01/12/2020

**Kambala Sport, Wellbeing and Senior Learning Precinct (SSD-10385)
Response to Submissions**

ATTACHMENT 1

PLANTING PLAN

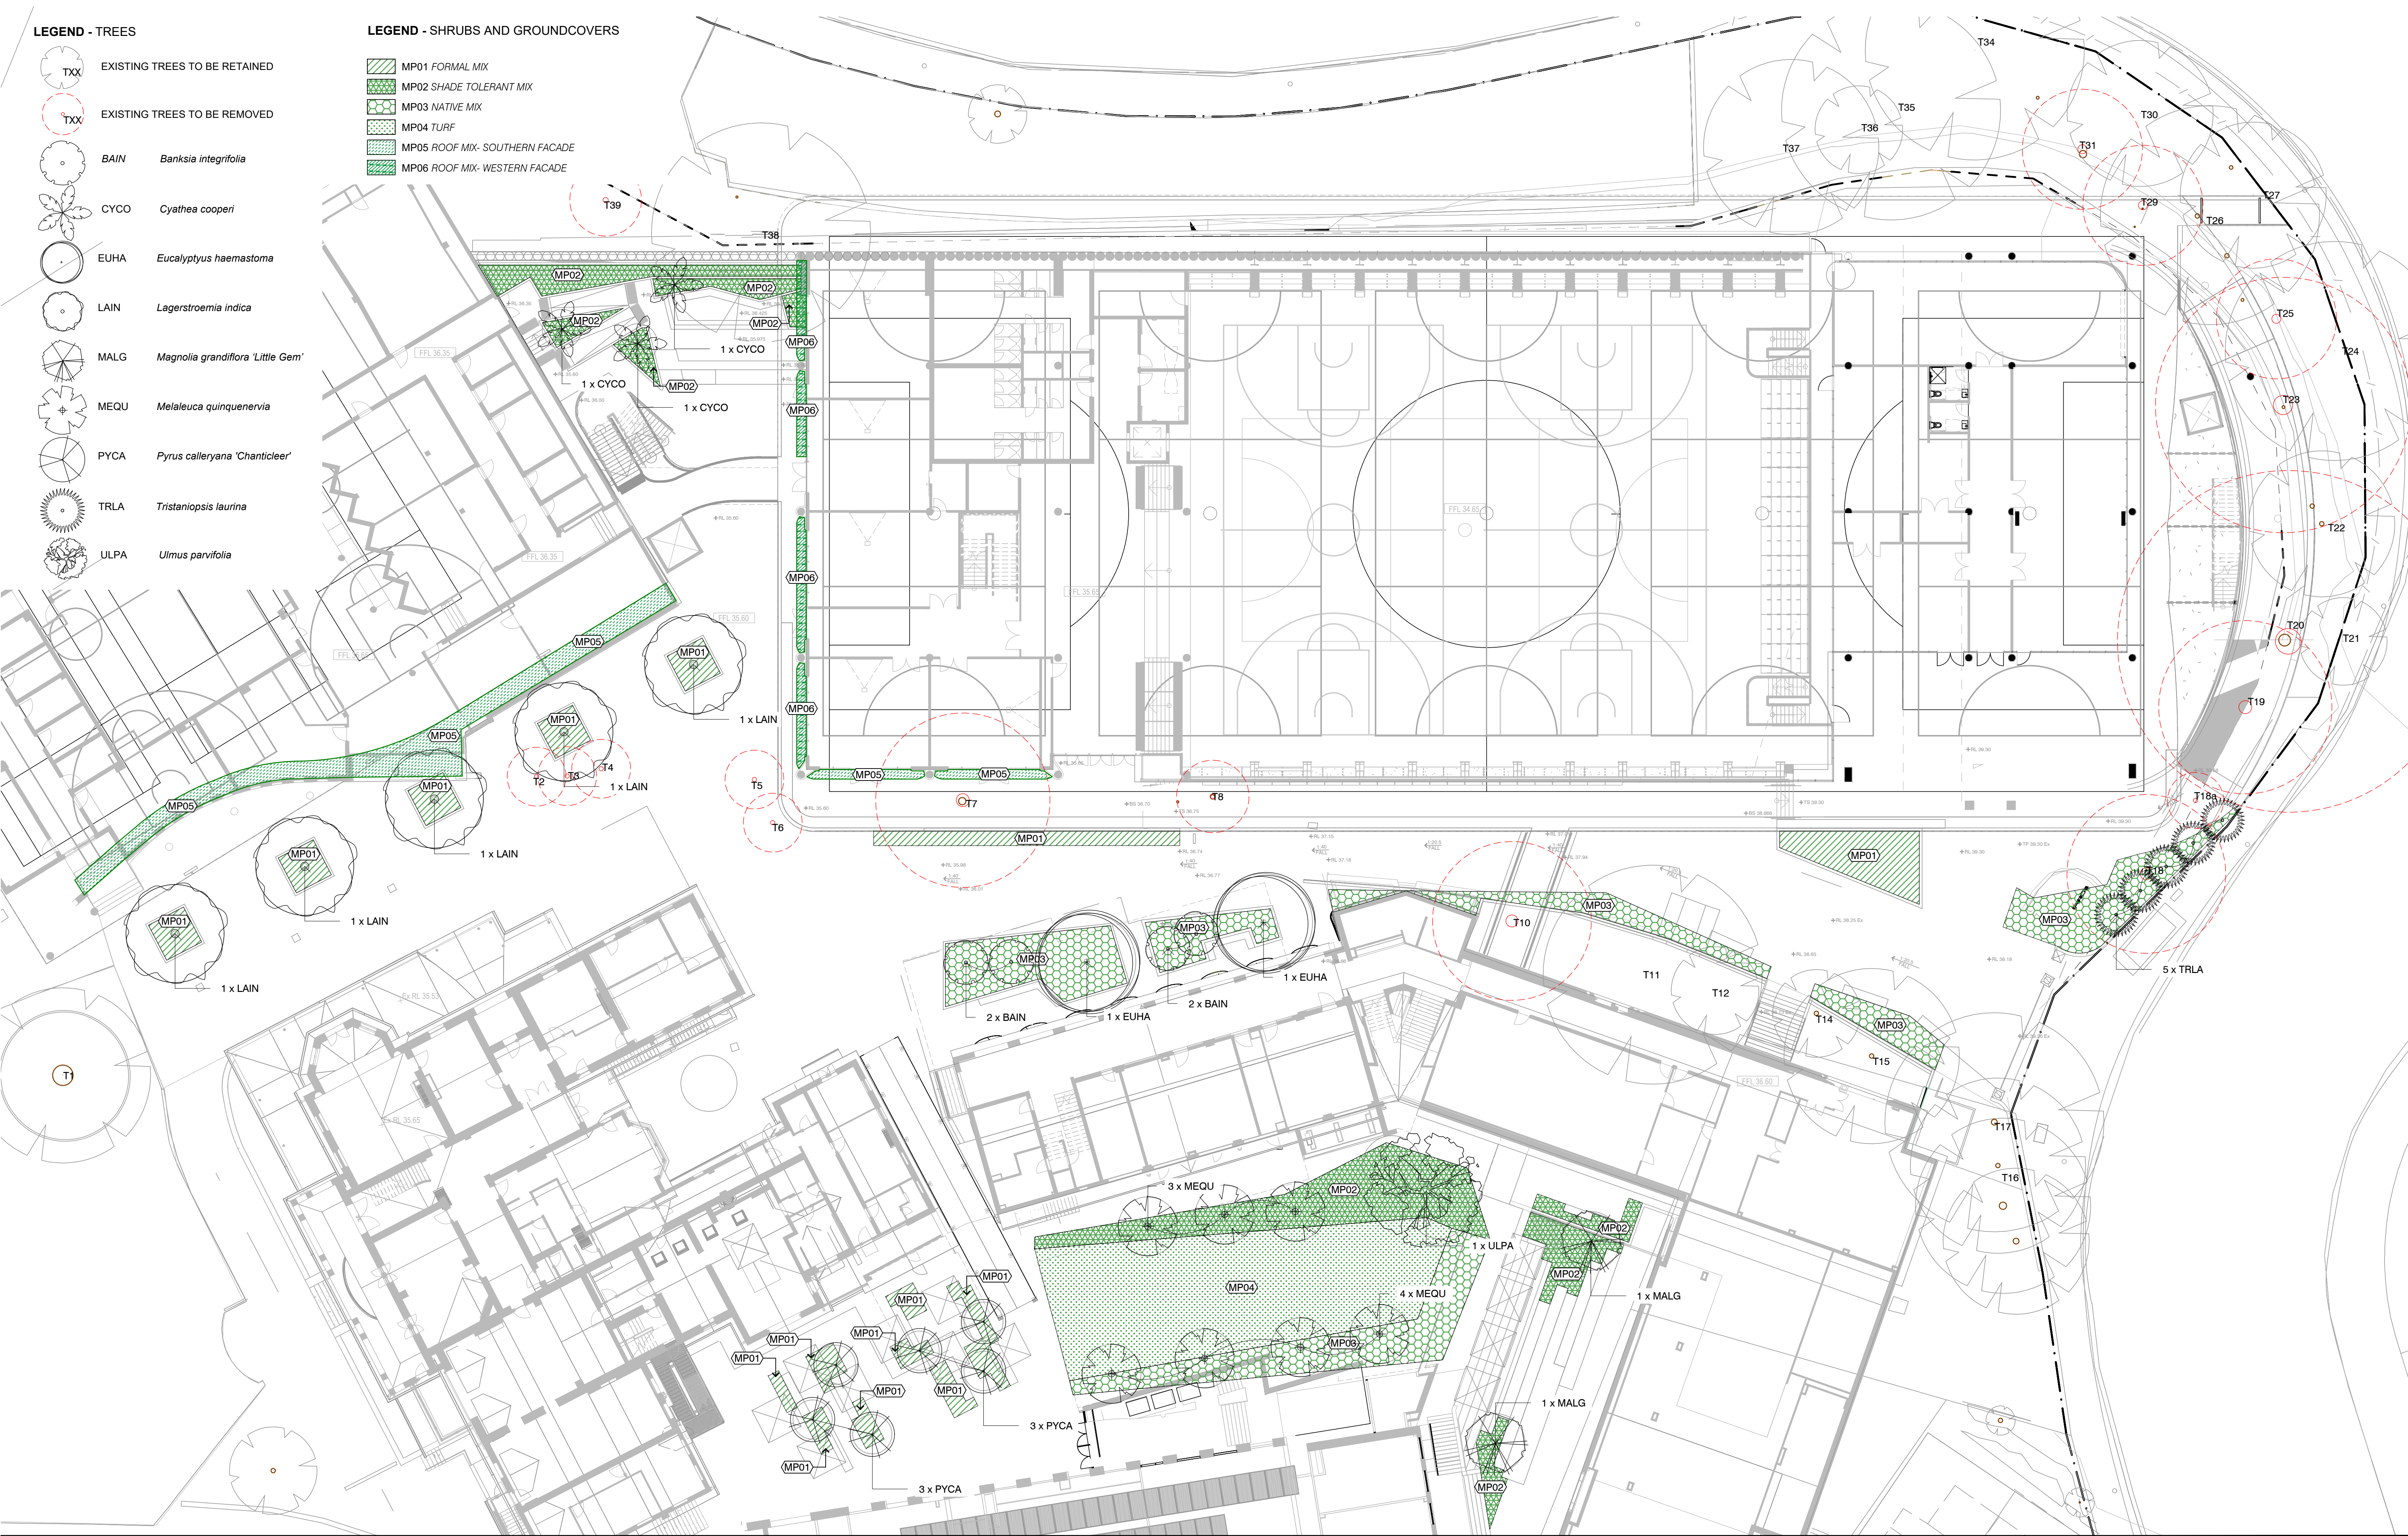
- A revised Landscape Plan that provides exact details of planting locations, species, quantities and pot size is to be submitted with the RtS.

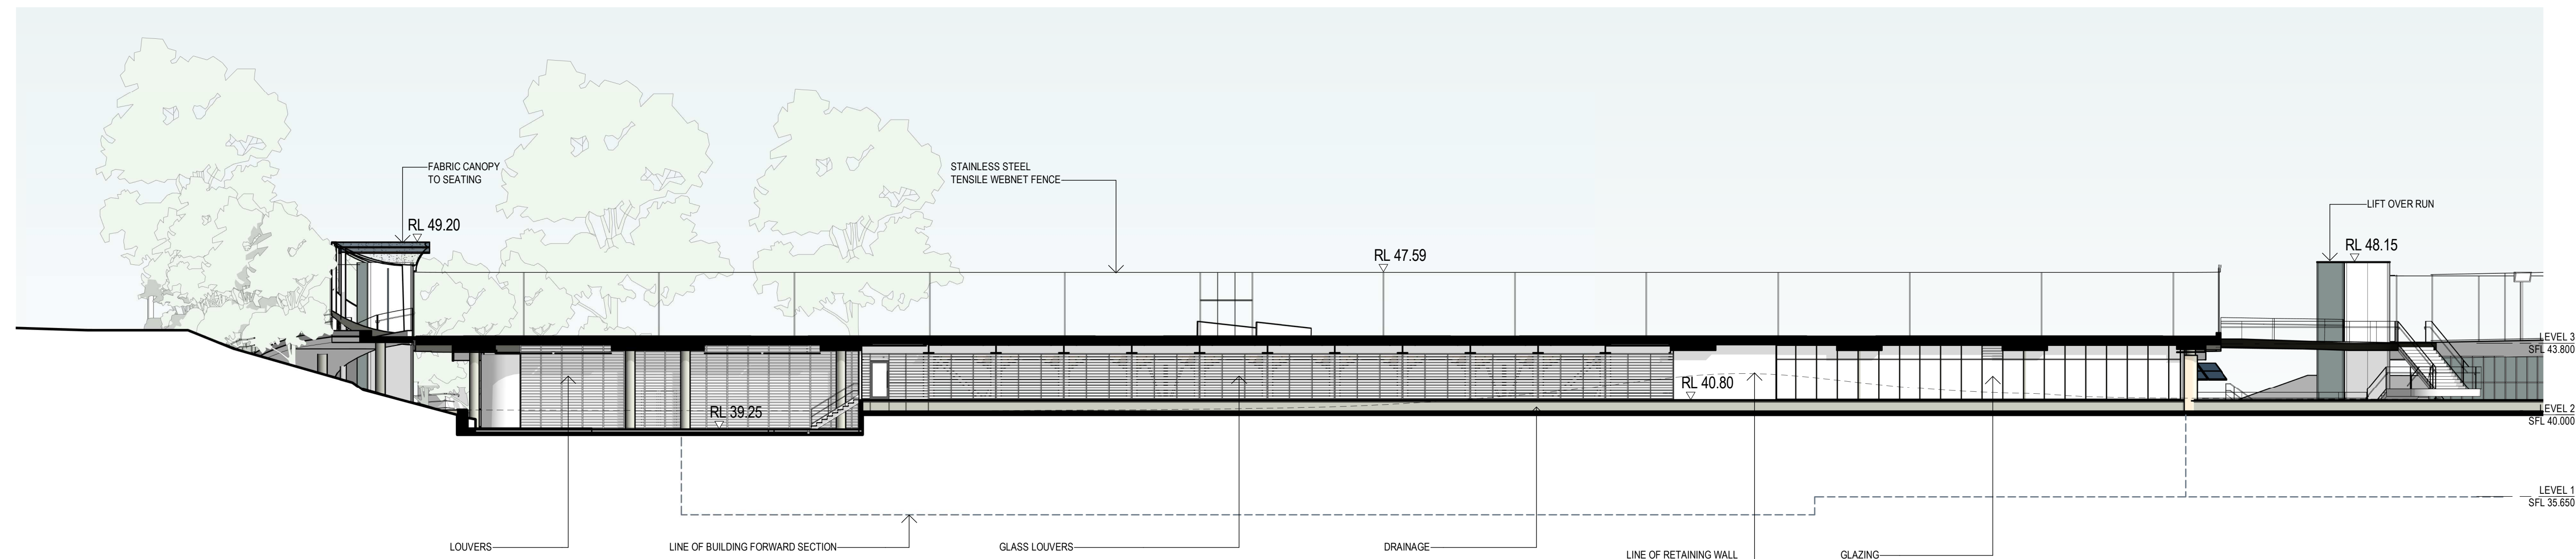
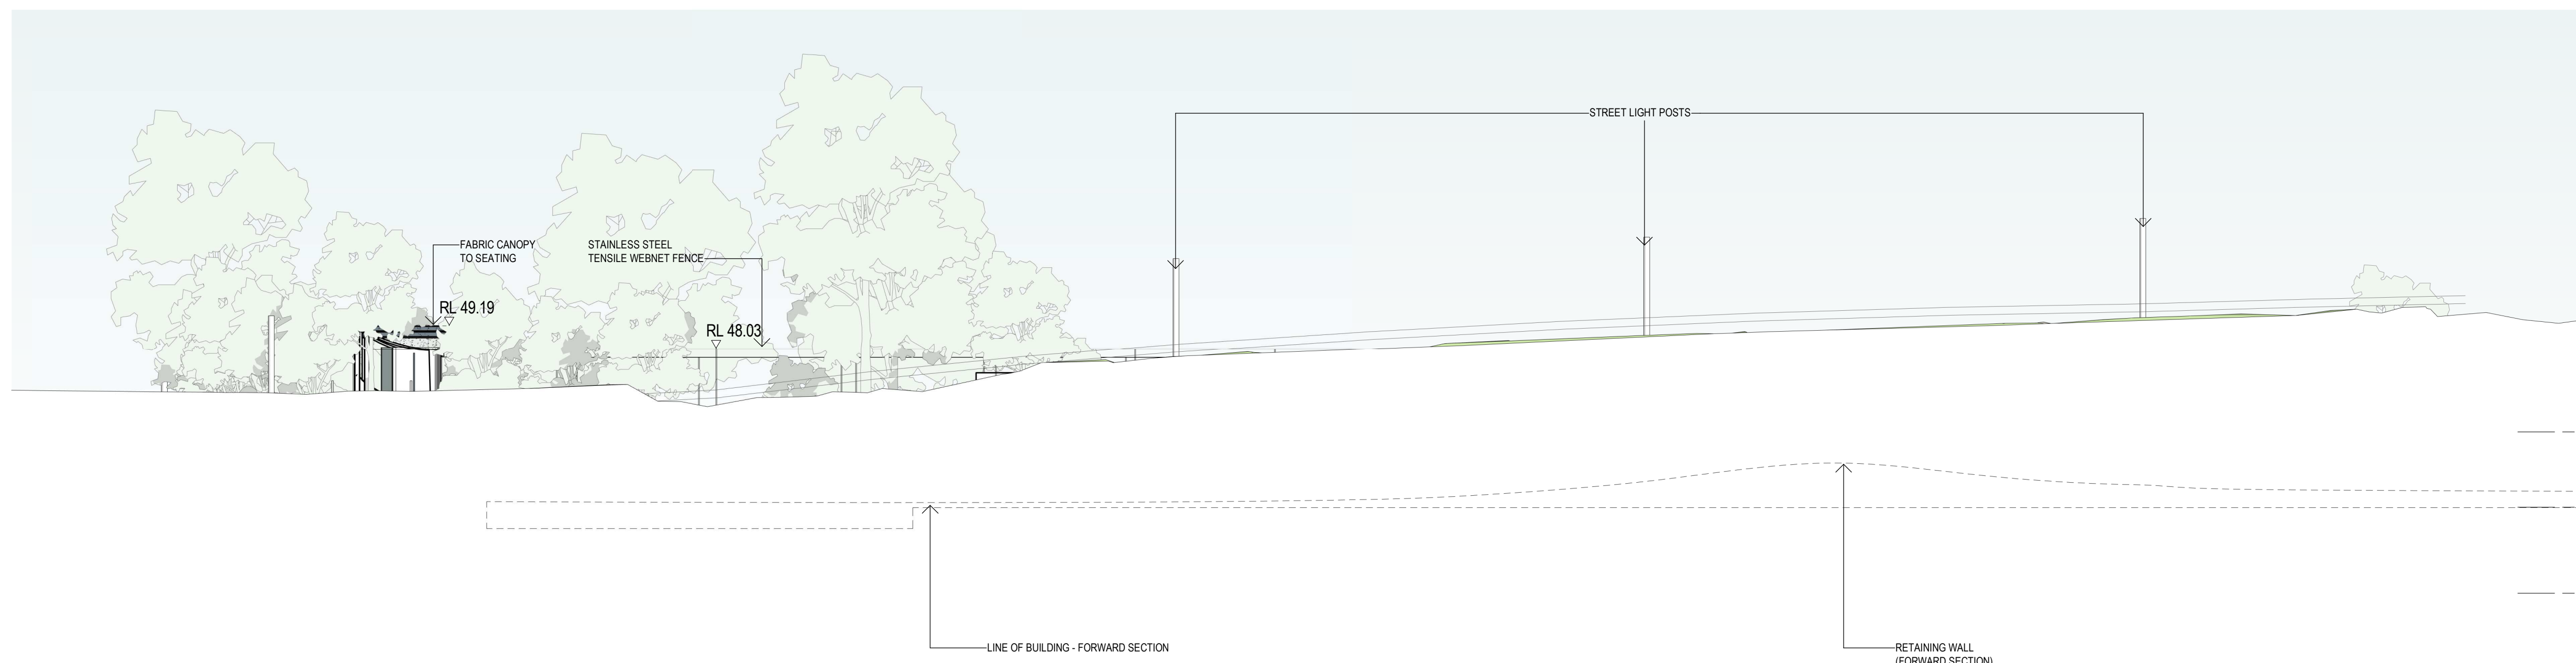
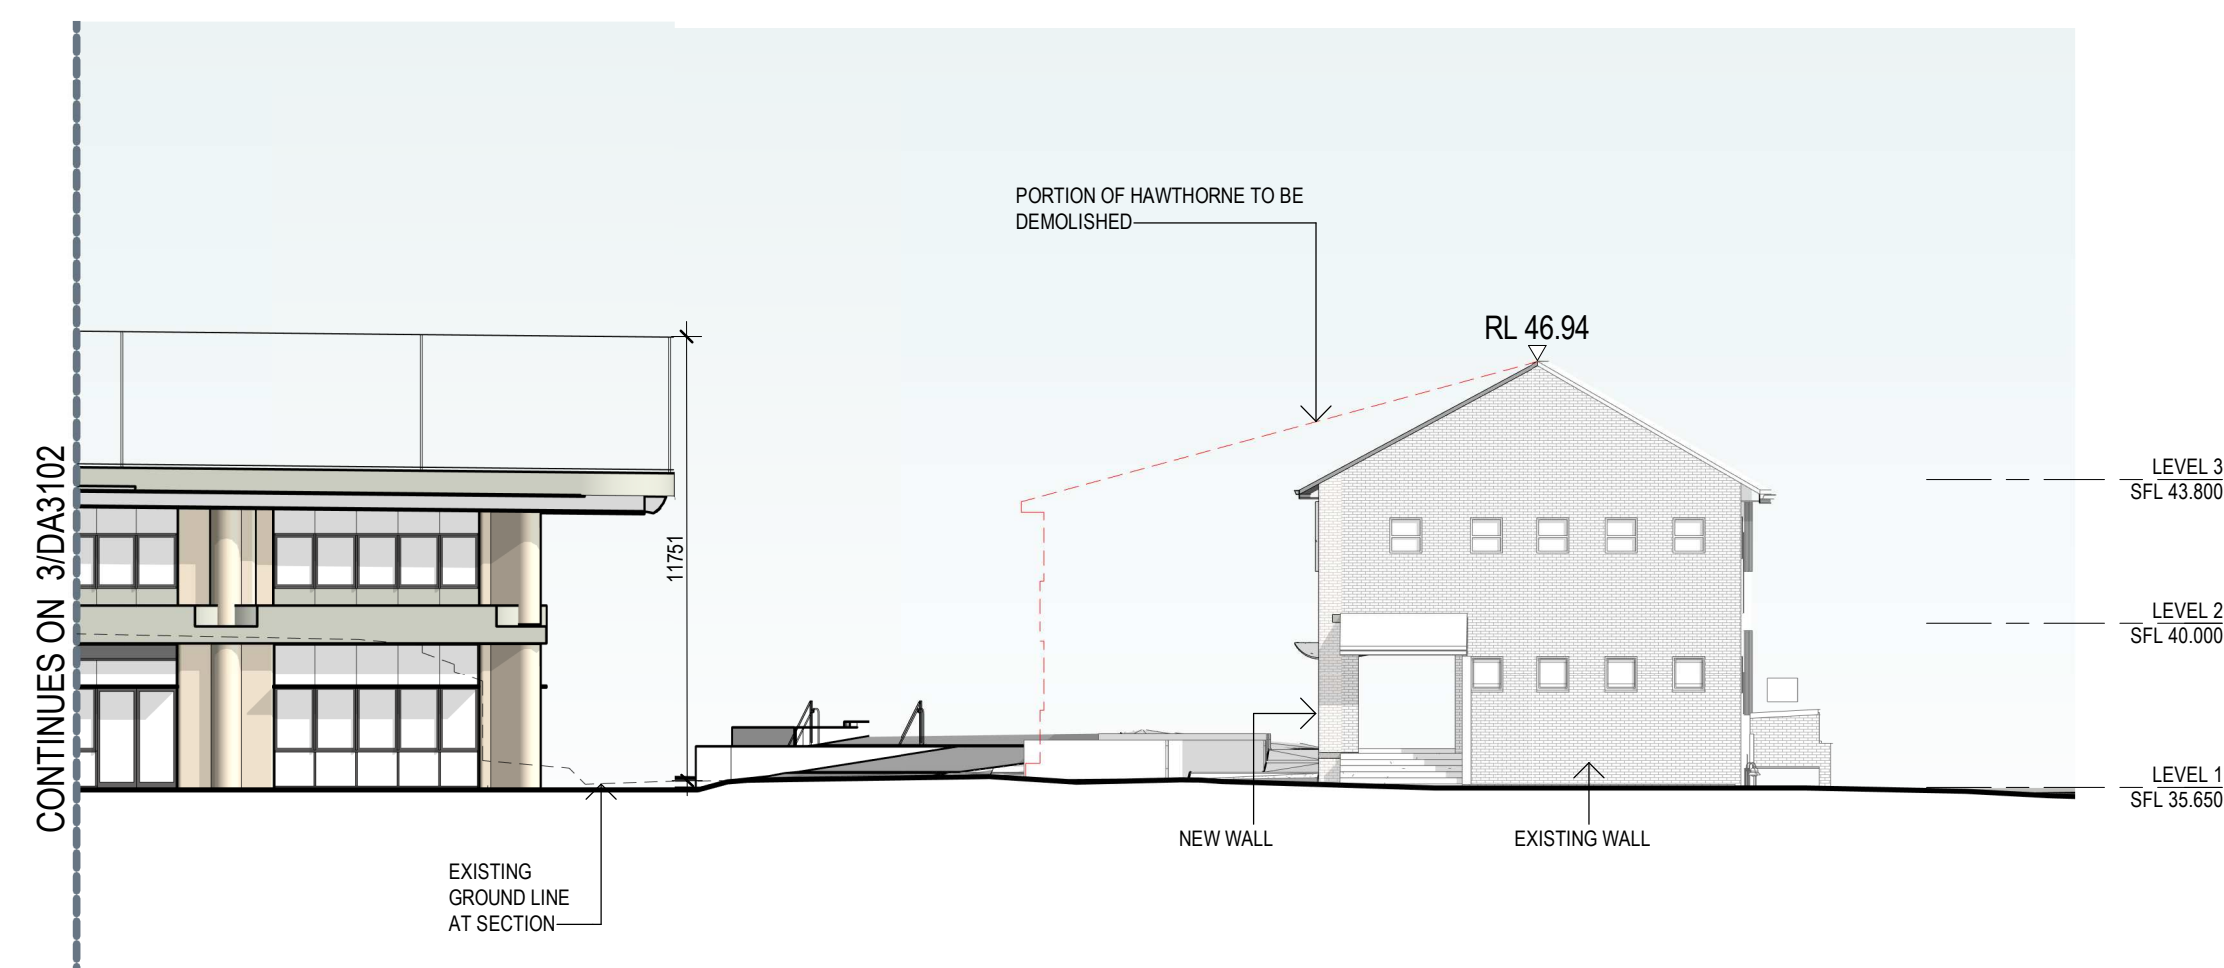
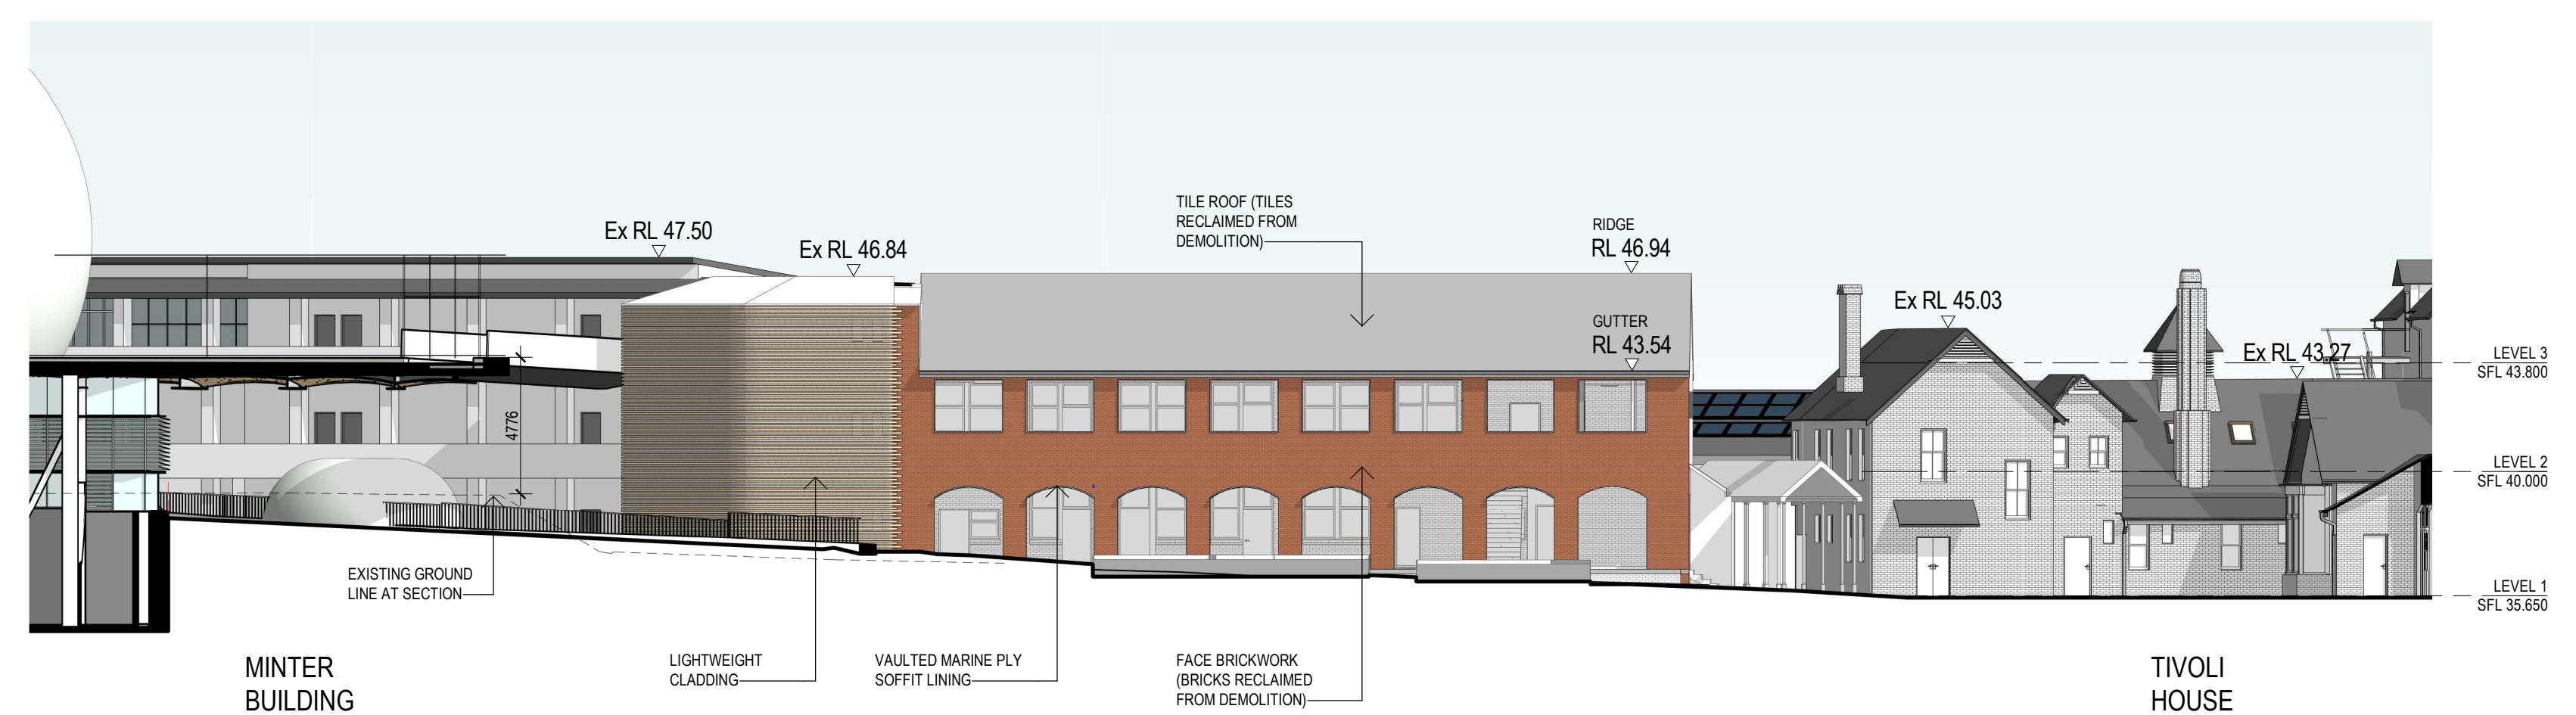
- The architectural plans should be updated to indicate the height of all buildings and structures from the existing ground levels in addition to the relative levels (RLs) shown.
- The submitted architectural plans include elevations with incomplete references. The RtS must include updated architectural plans with elevations of all facades of each of the new buildings proposed that are clearly labelled to include North, South, East and West.
